Application no: **3/2023/1014**

Address: **Curtis House Chipping Road Longridge PR3 2NB**

Proposal: **Proposed change of use from one dwelling into two.**

The Local Highway Authority have viewed the plans and highway related documents and have the following comments to make:

Job/Scheme Number		Drawing Number	
0723/93		Drawing No 03C	
Scale	Date	Drawn	Checked
1/500	Dec 23	a.t.l-h.

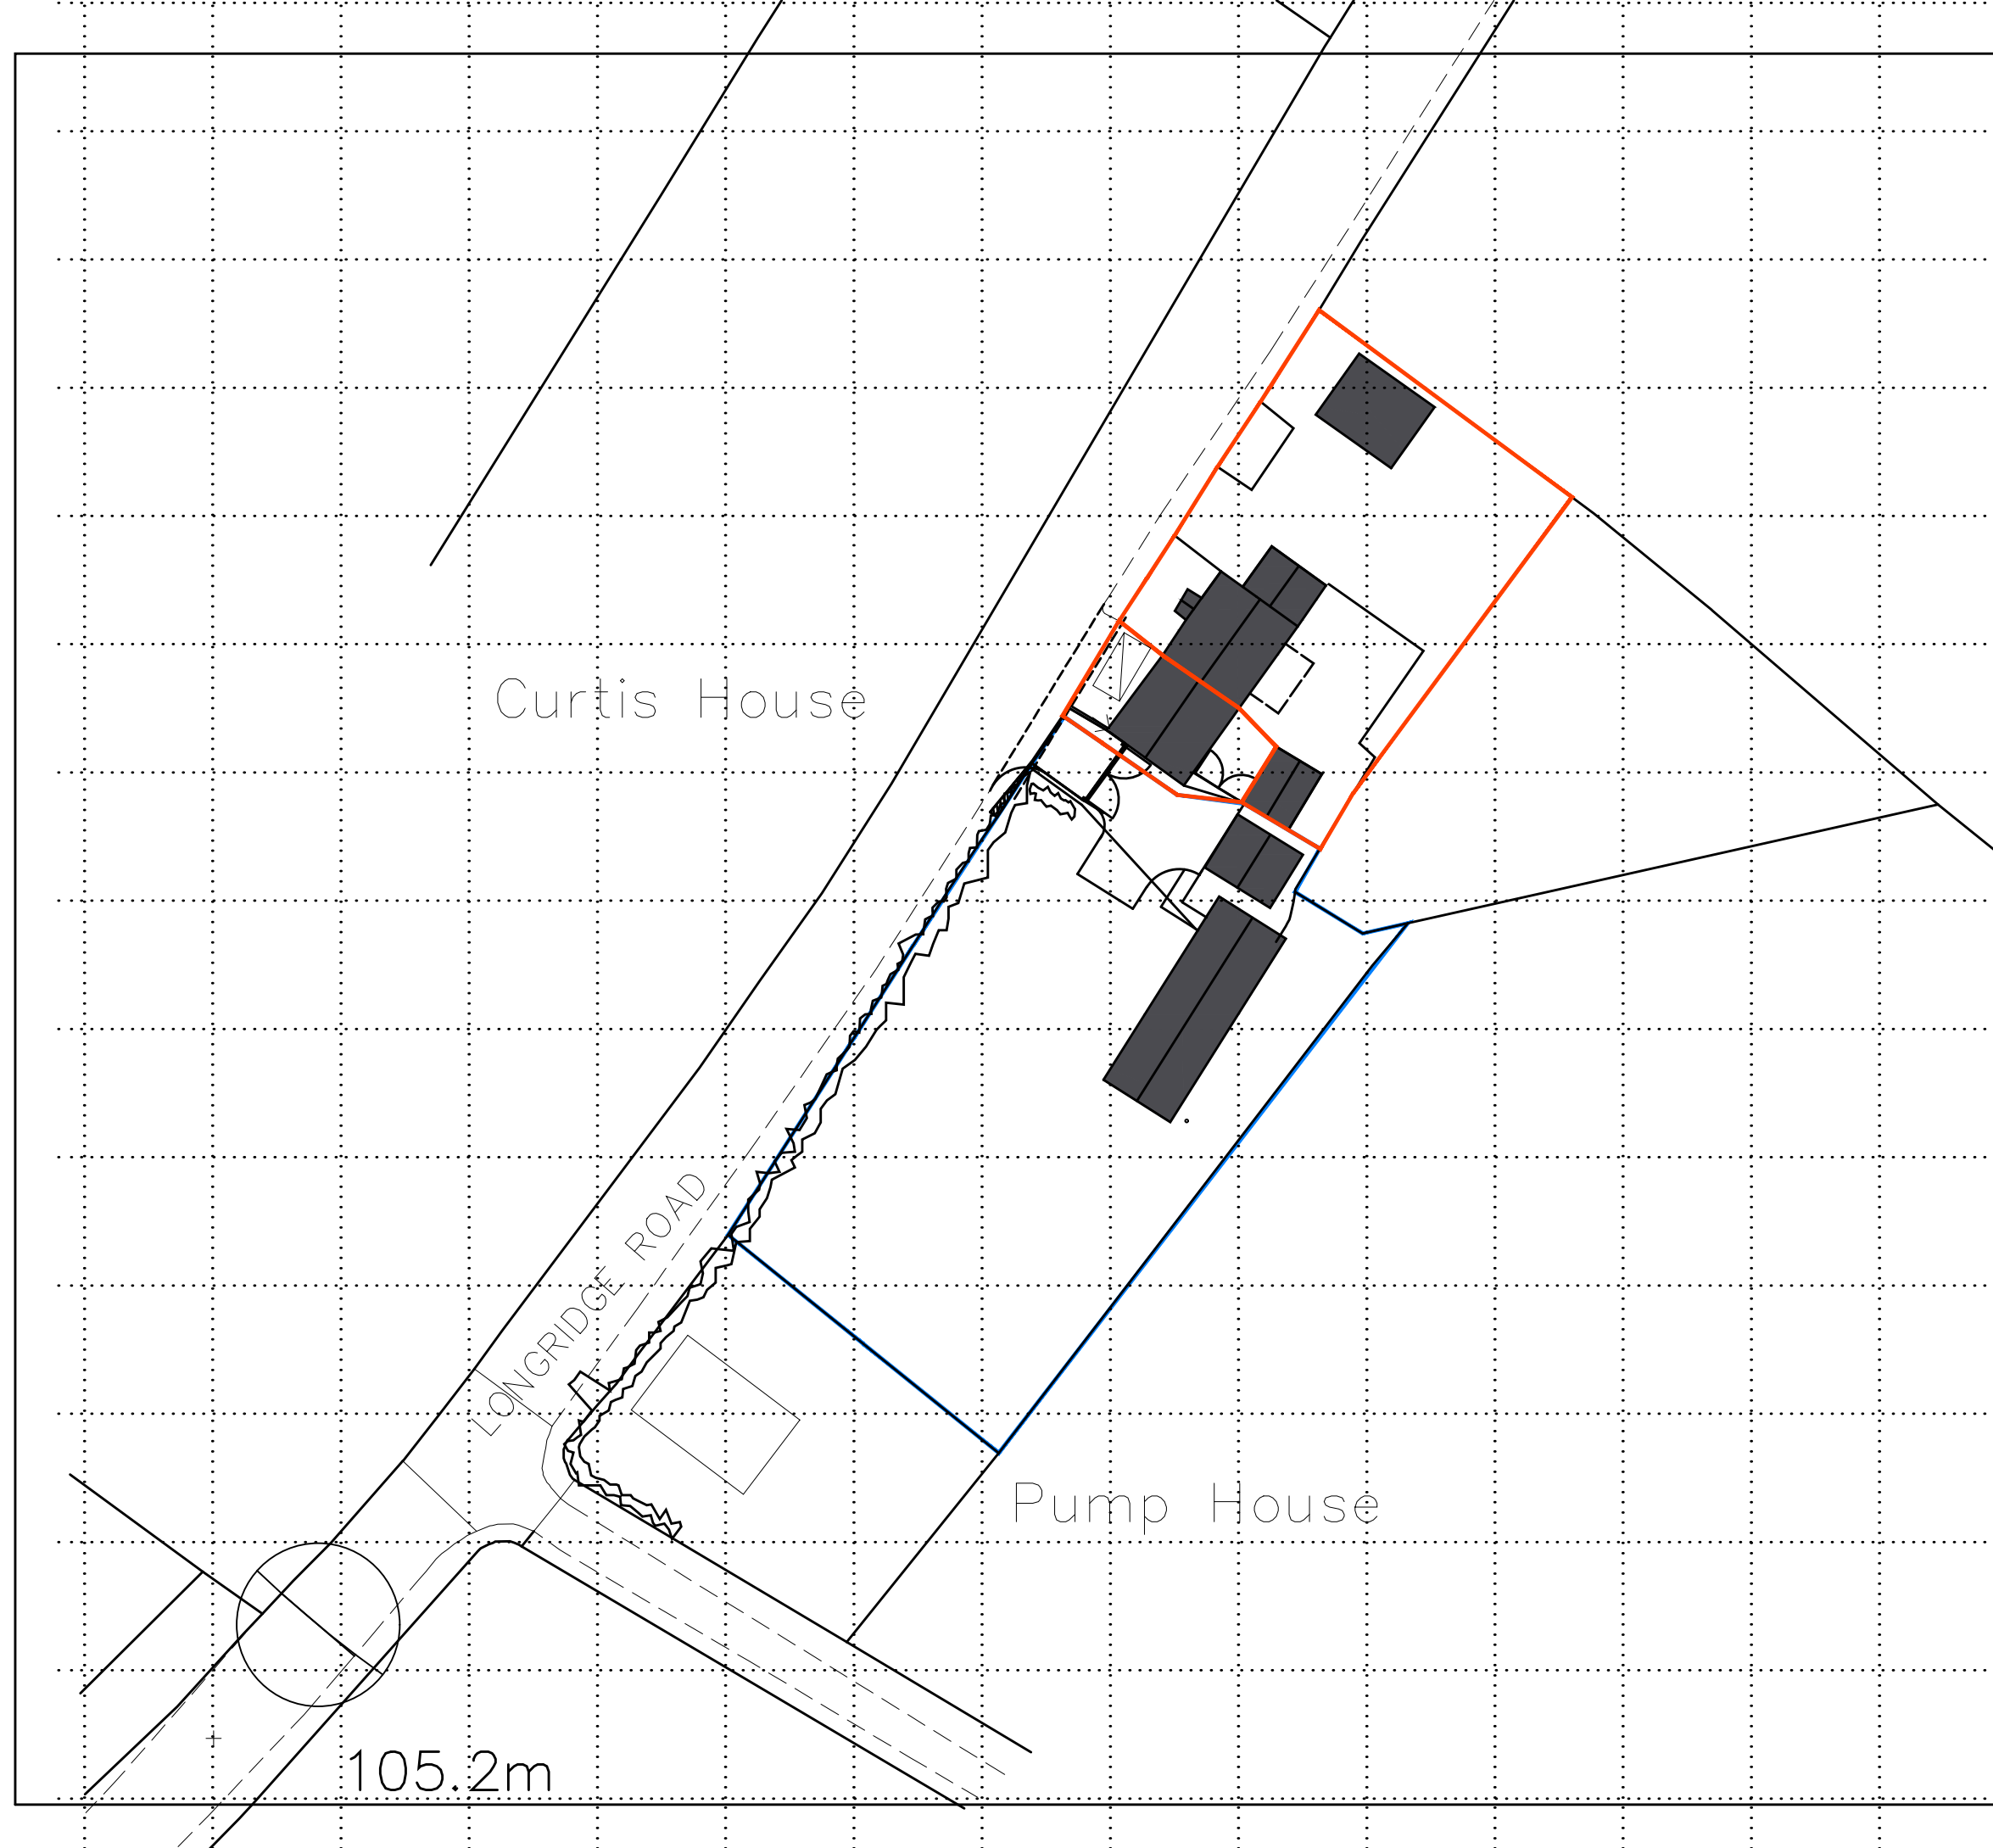
The LHA have reviewed ALH drawing number 03C titled "Existing Site Plan" and require a parking plan to be submitted showing that each proposed dwelling can provide a minimum of 2 car parking spaces. This is so that the site can comply with the LHAs parking guidance as defined within the Joint Lancashire Structure Plan.

Currently, as shown on ALH drawing number 03C, one car parking space is provided on the concrete apron which is located directly off Chipping Road. This space has been designated to serve the "new barn conversion" as labelled on ALH drawing number 11 titled "Proposed Floor Plans (First Floor)". However, the LHA are unable to accept a parking space being created in this location. This is because the depth of the area is less than 4.8m and the LHA do not accept off-street spaces being provided parallel to the dwelling or the adopted highway. Even if the LHA did accept the space, there would still be a shortfall of one car parking space and the location of the space is strange given that the door to access the property is located to the rear of the site.

As a result of no parking plan being submitted and the designated area for the "new barn conversion" being unsuitable, the LHA require an amended plan to be submitted.

The LHA require an amended plan to be submitted showing where each dwelling will park, and an access drawing will be required showing how these areas will be accessed.

On the access drawing details should emerge regarding the access width and the access' visibility splays, with the LHA requiring an access located off a 60mph road to provide visibility splays of 2.4m x 214m in both directions.
